Project Name: India Newbury Residences  
Address: 62 India Street  
Applicant: India Newbury Residences, LLC  
Planner: Caitlin Cameron

Project ID: 2016-096  
CBL: 028 P008, P009, P015, P019, P020

**TO:** Caitlin Cameron, Planner  
**FROM:** Lauren Swett, PE  
**DATE:** May 16, 2016  
**RE:** 62 India Street, Site Plan Application – Response to Comments

Re: Final Review Comments for 62 India Street – India Newbury Residences,  
LLC (2016-052)

LOWER LEVEL PLAN
SCALE: 1"=20'-0"

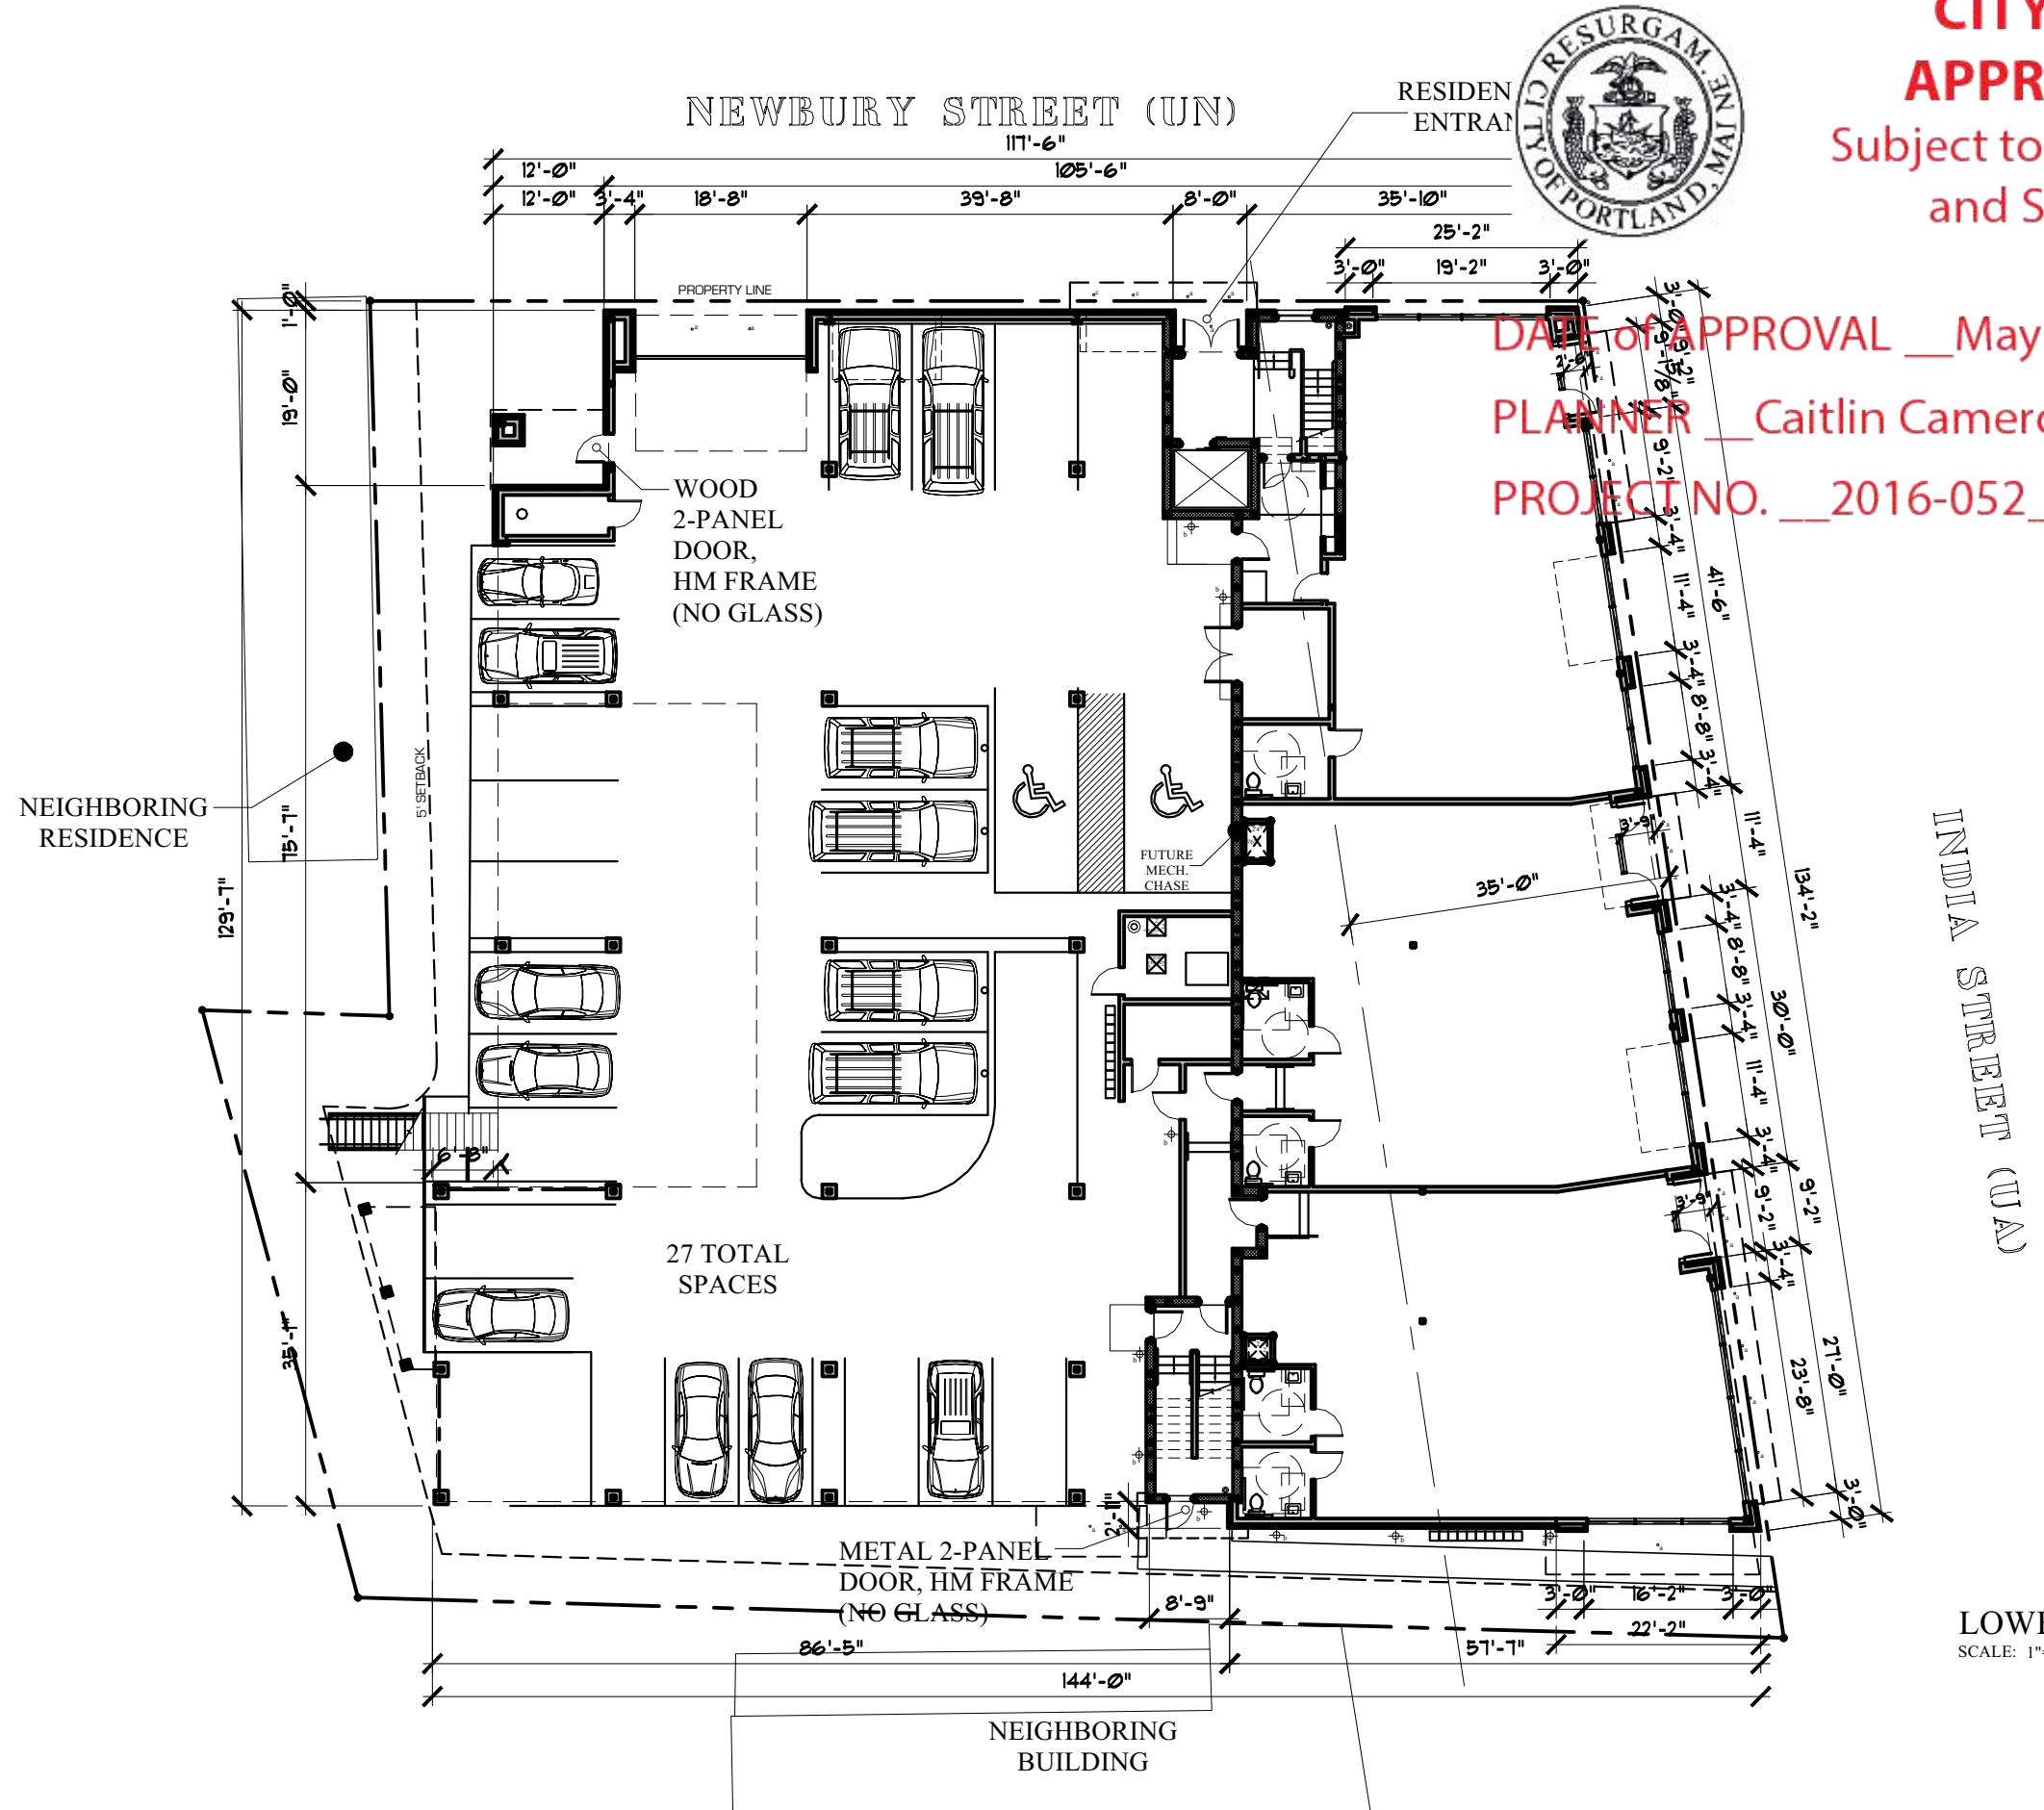
- The applicant should provide information that notes the ADA parking spaces meet dimensional ADA requirements and are accessible given the location of the building column.

**Status: The applicant should document that the spaces meet ADA requirements as a condition of approval.**

Drawing file: Final Approved Stamp_1018541 / Subdivision Plat.pdf

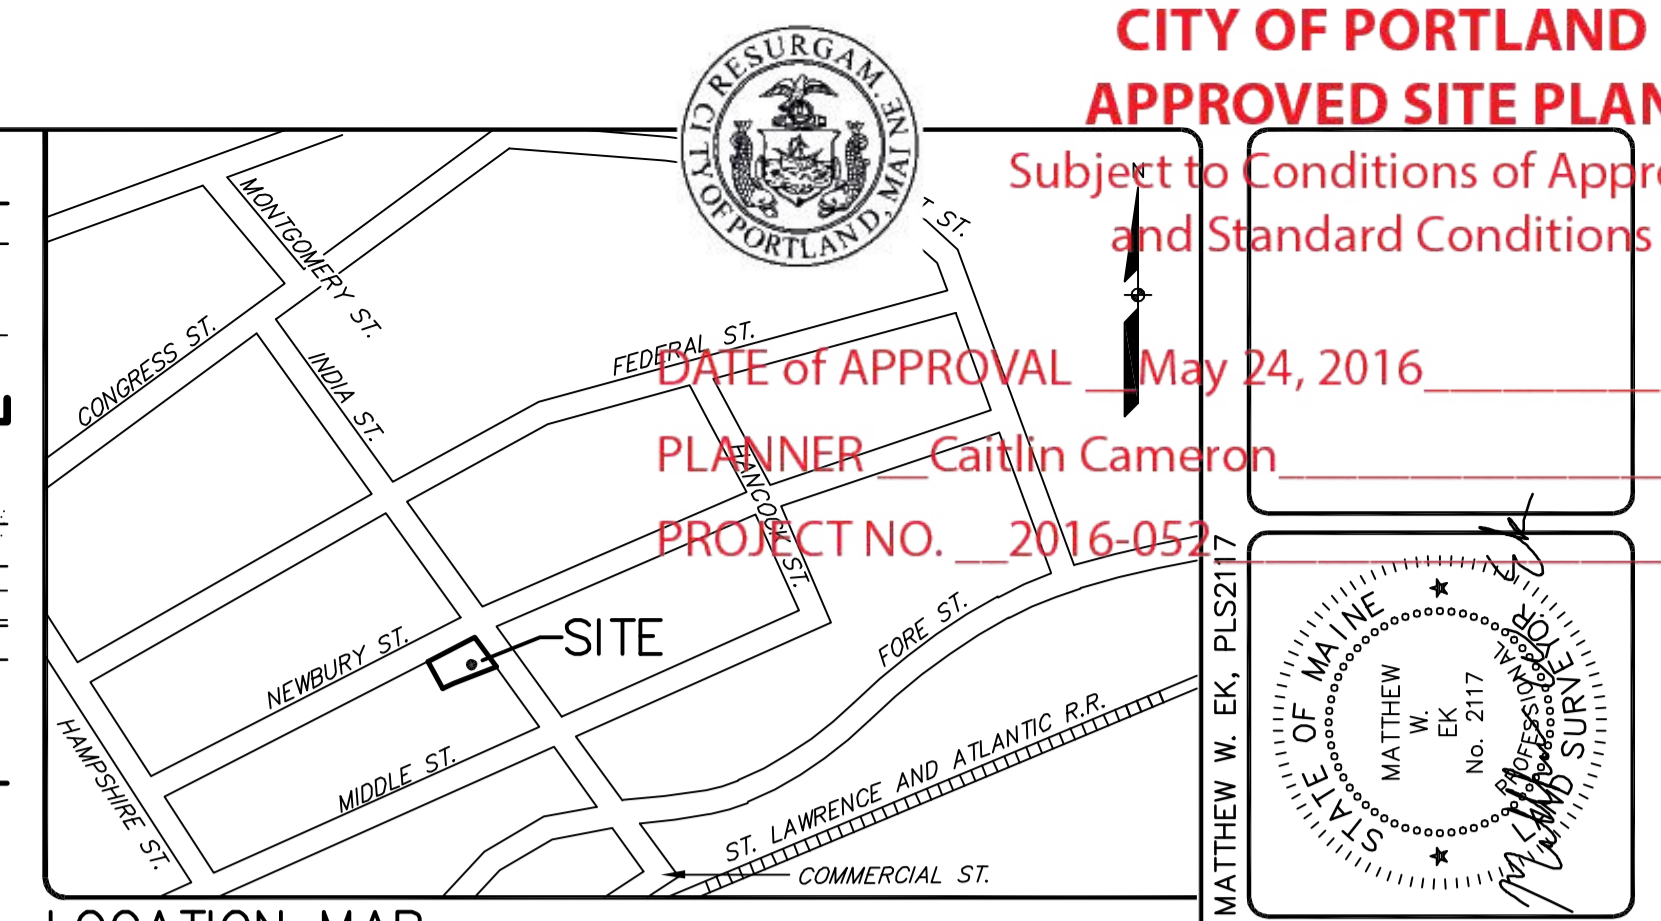
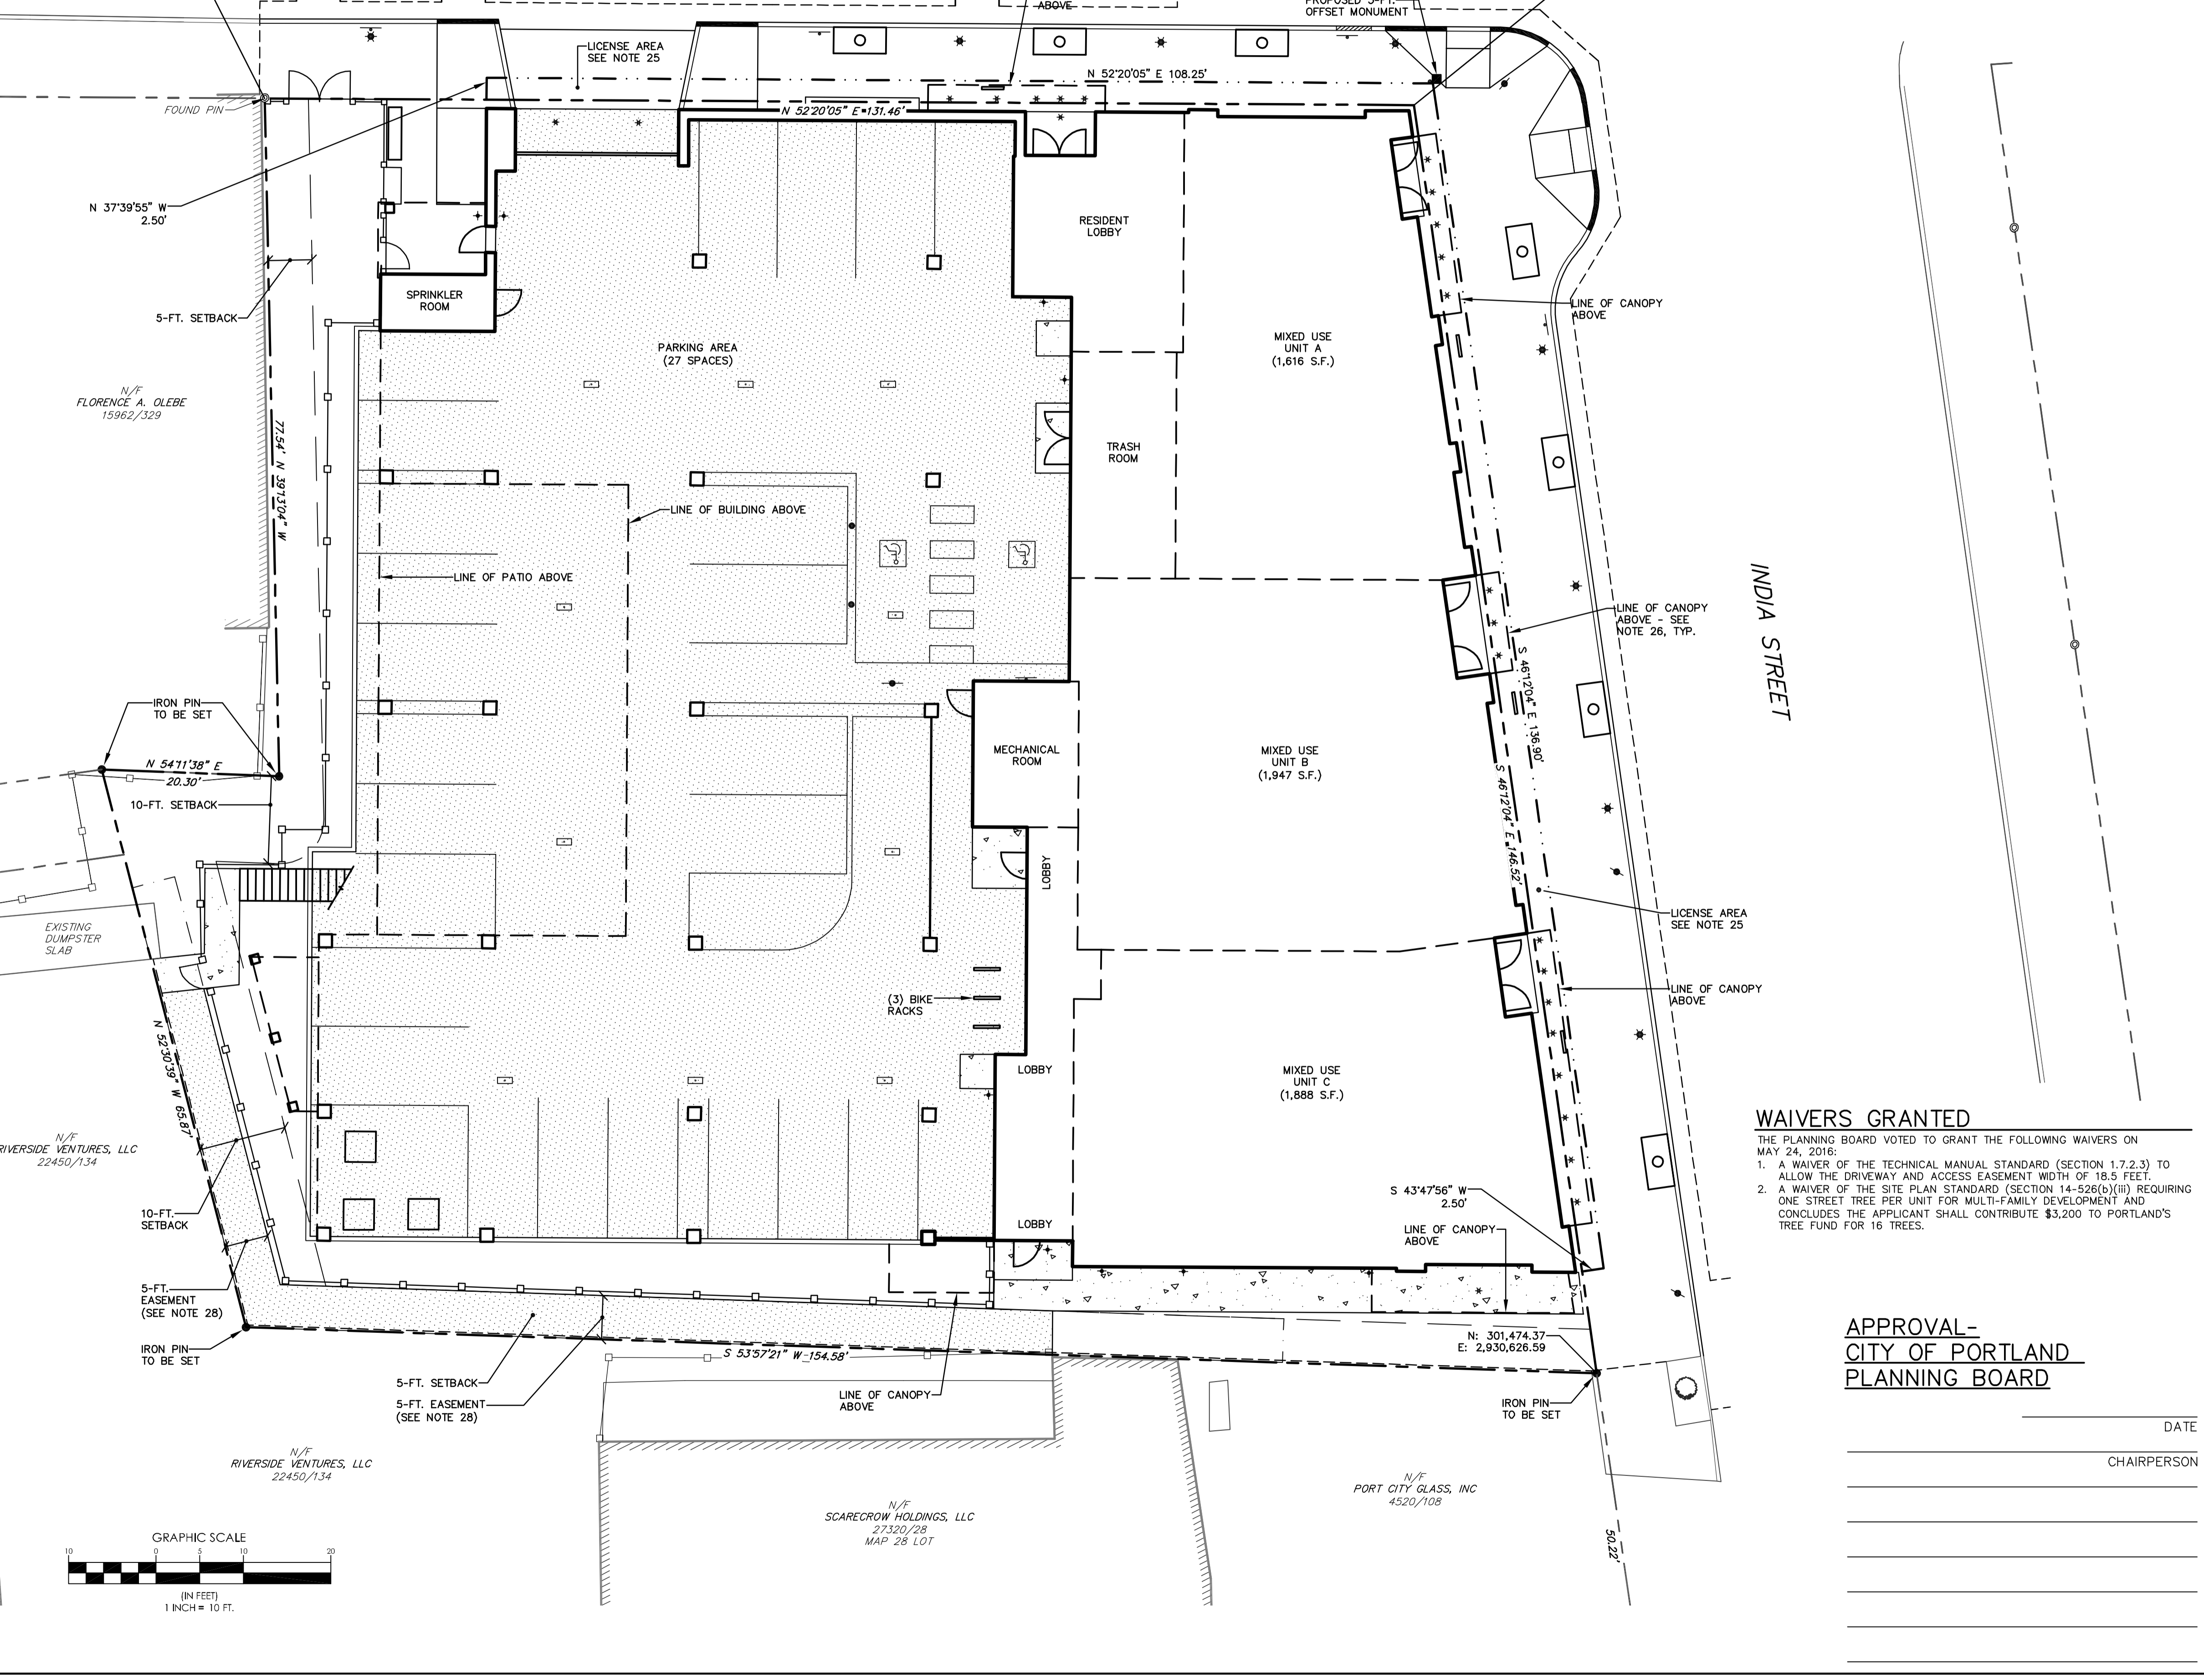
“The proposed three foot offset monument center needs to be at the intersection of the three foot offset lines; on the plan the corner of the monument is shown at the intersection of the three foot offset lines.”
